Application for Removal or Variation of a Condition following Grant of Planning Permission or Listed Building Consent

Northdene

Proposed extension to the current ground floor of the dwelling house to provide a utility room and in addition, to alter the current garage to the rear of the dwelling house by extending it to form an indoor swimming pool.

3/2013/0584

ground floor plan

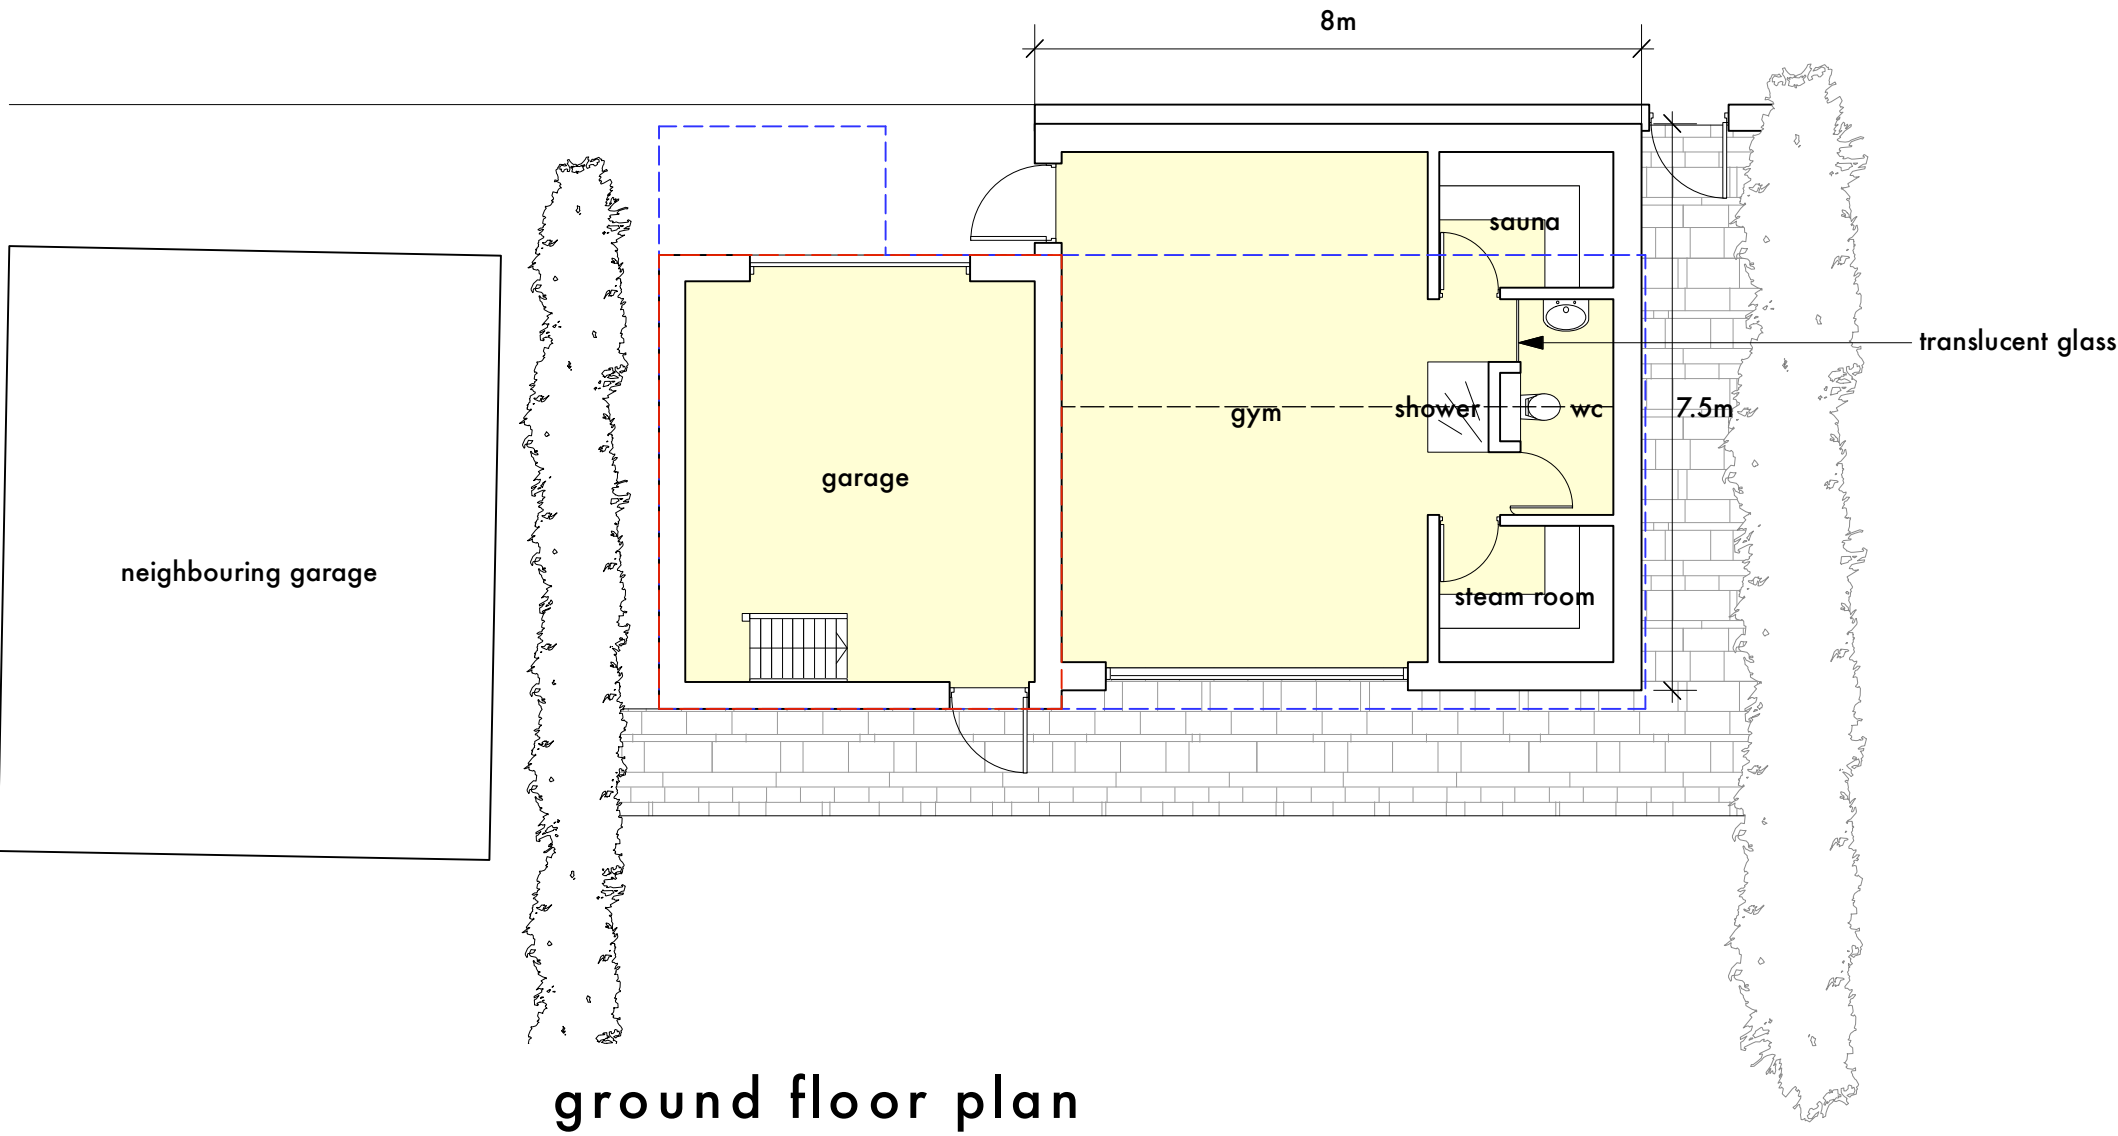
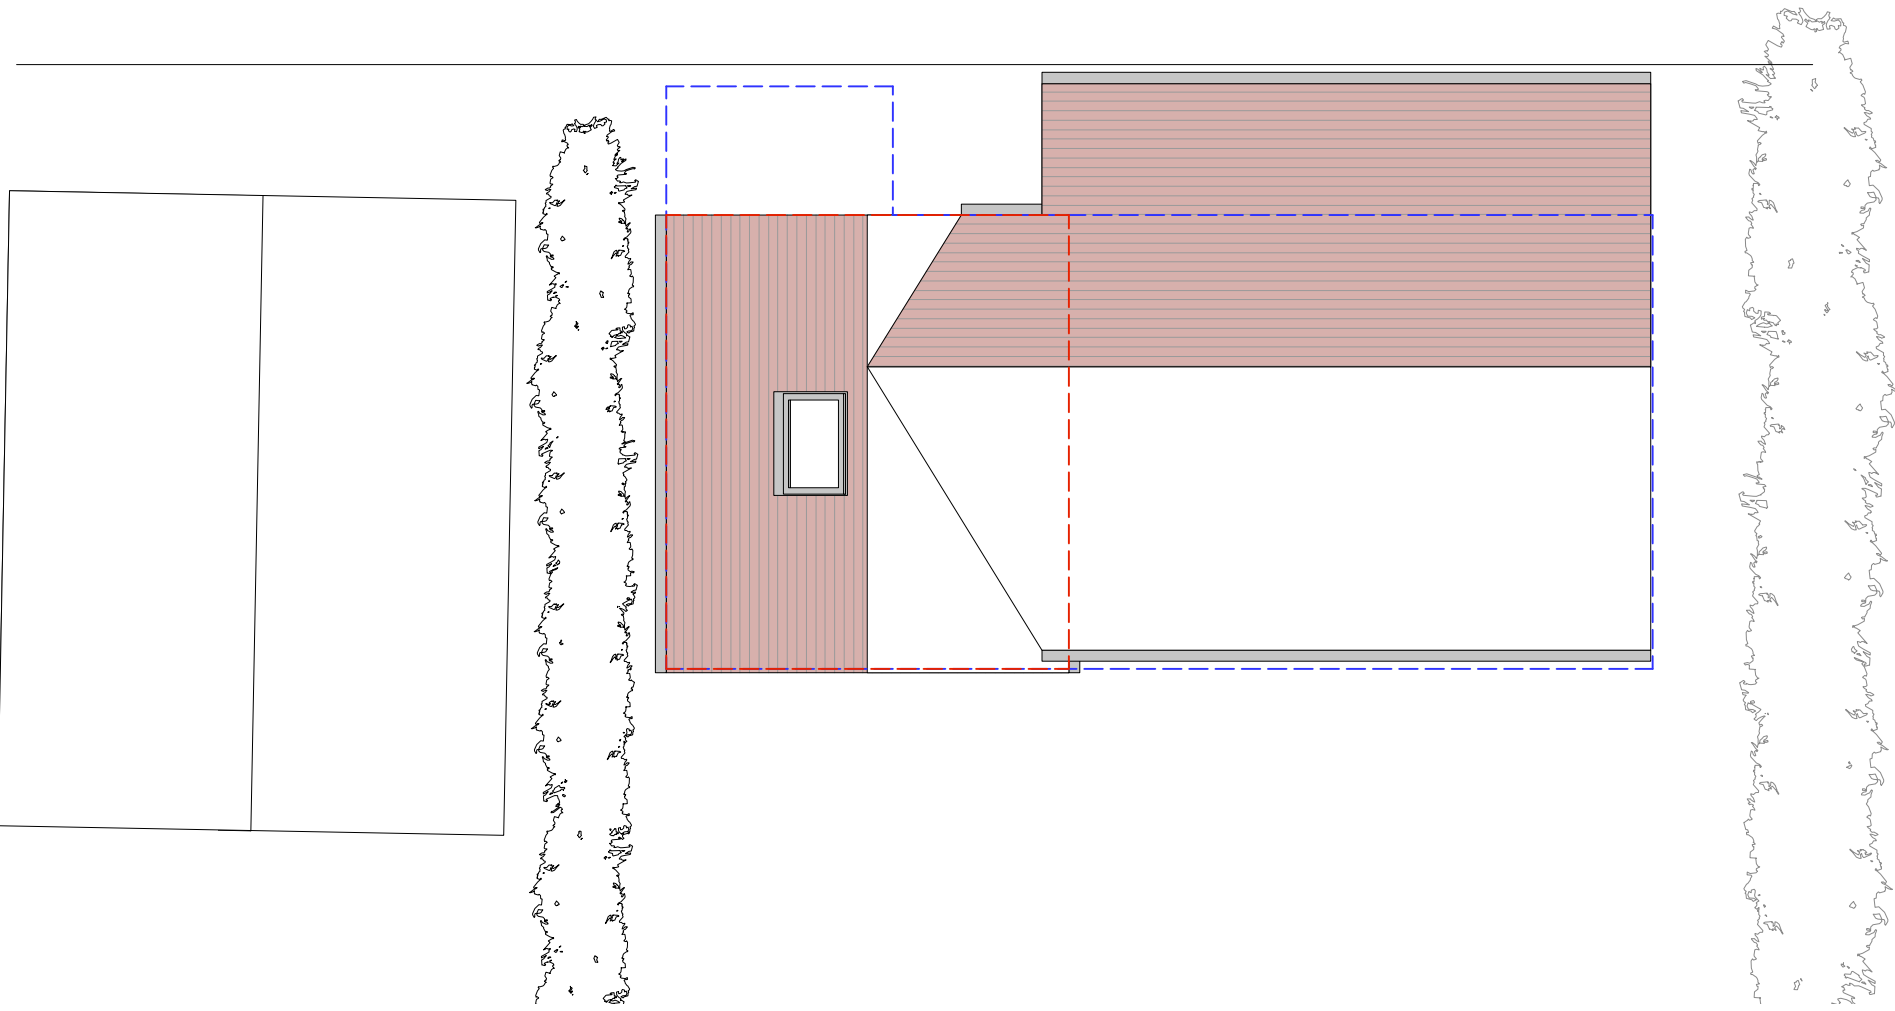
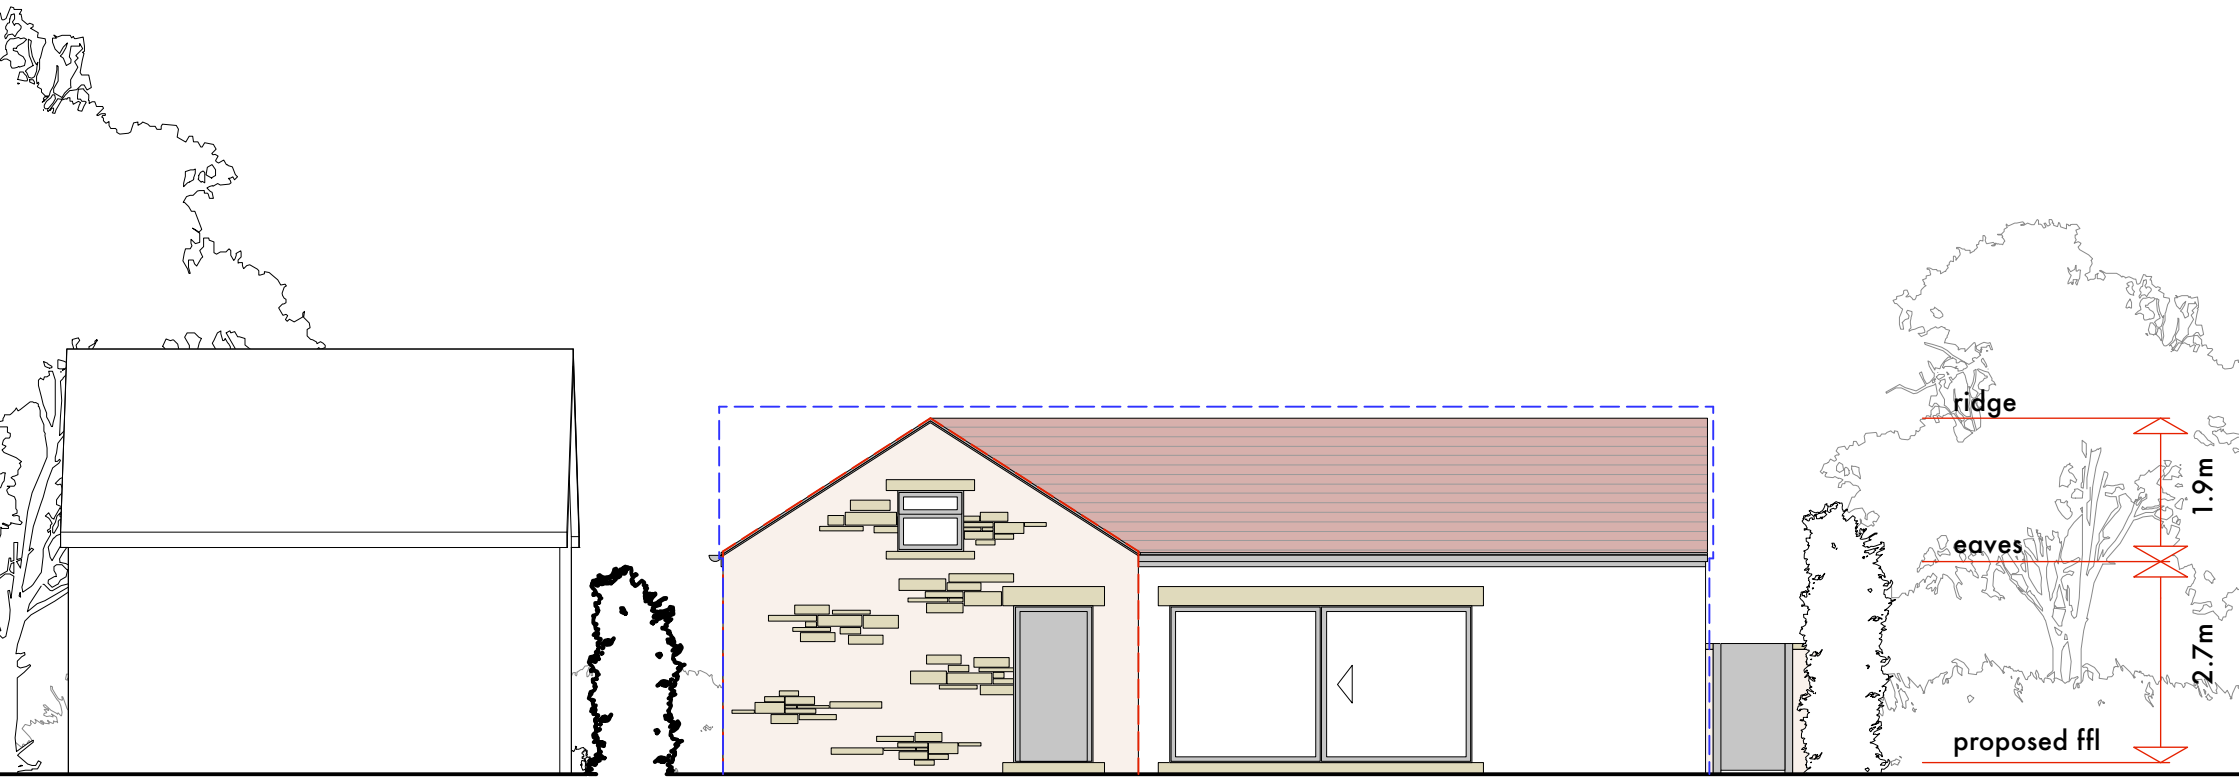
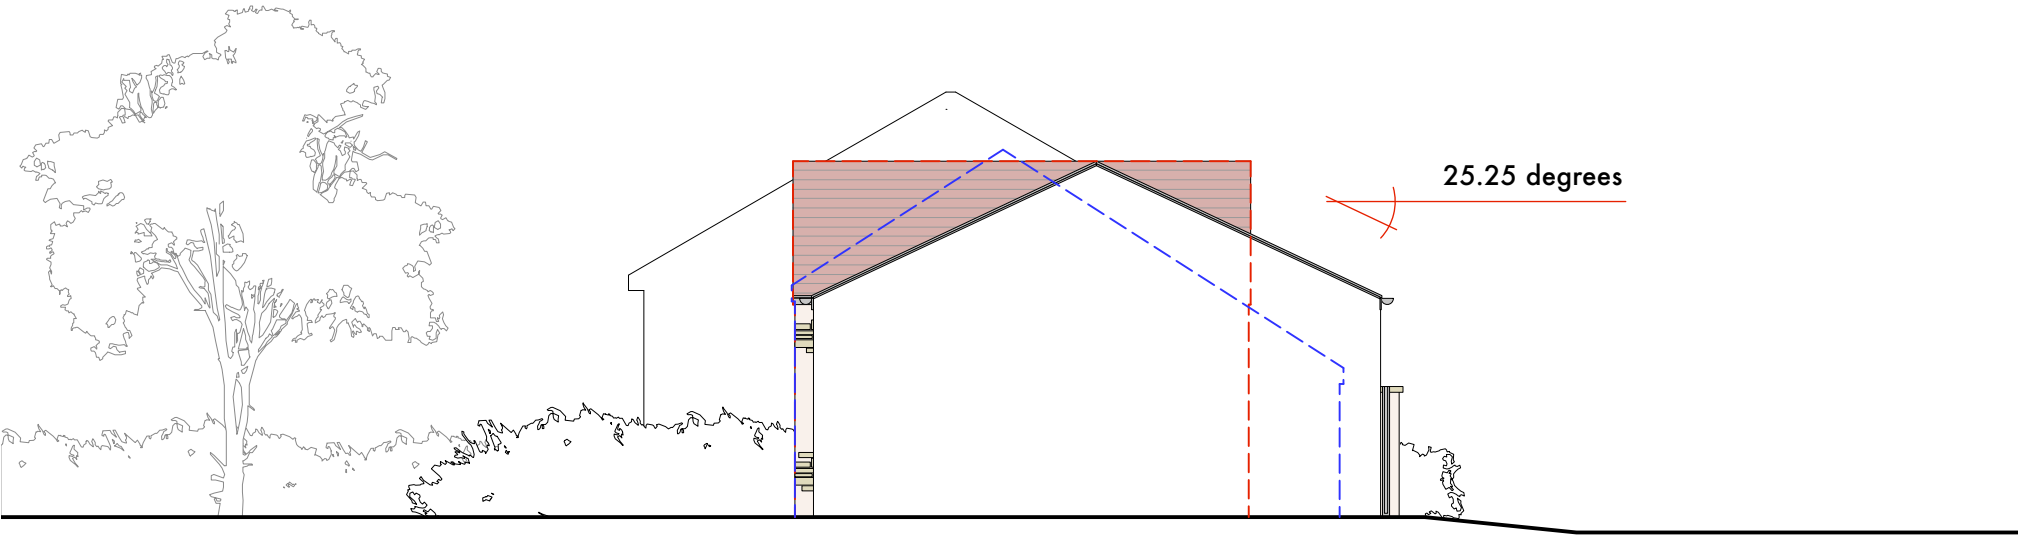
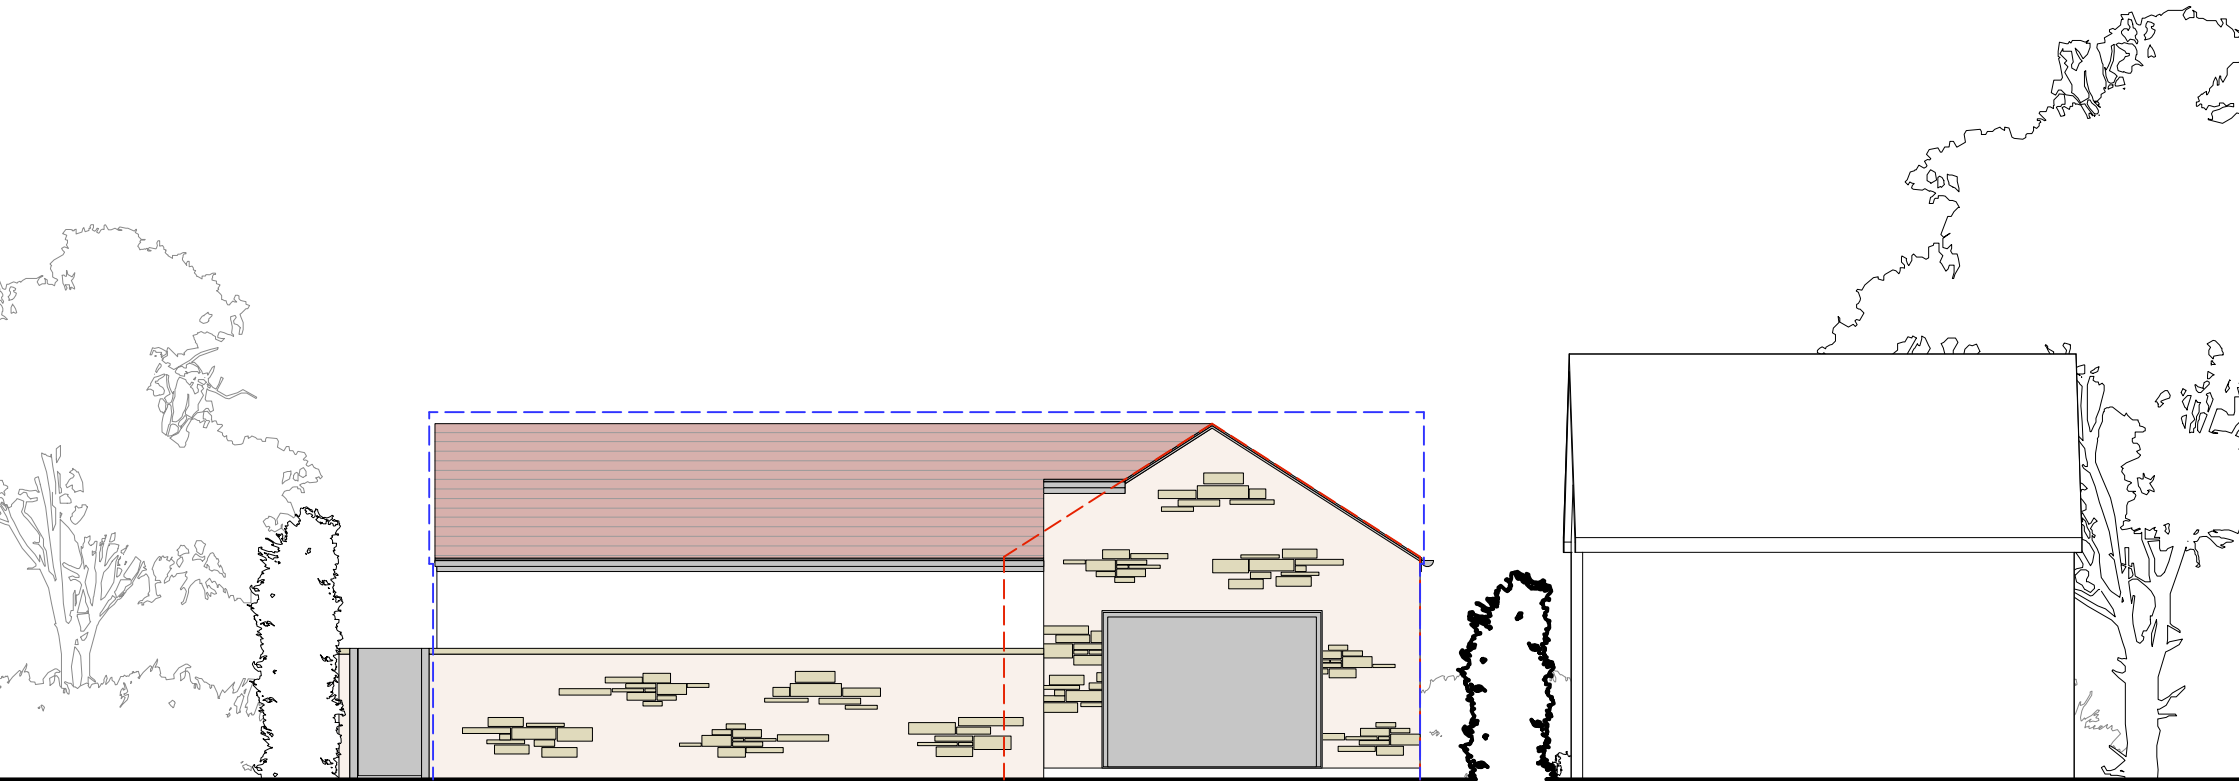
Condition 2 relates to the drawings for the proposed swimming pool DRG NO: P308_002P1 Rev2. This drawings shows the existing garage demolished and replaced by a new building. Our client (the applicant) would like to retain the garage and build a smaller extension. This condition should be changed.

Condition 2 should be changed to the following:

The permission shall relate to the development as shown on plan reference:

Proposed Garage/Garden Room Plans and Elevations - DRG NO: 2275/PL01revA.
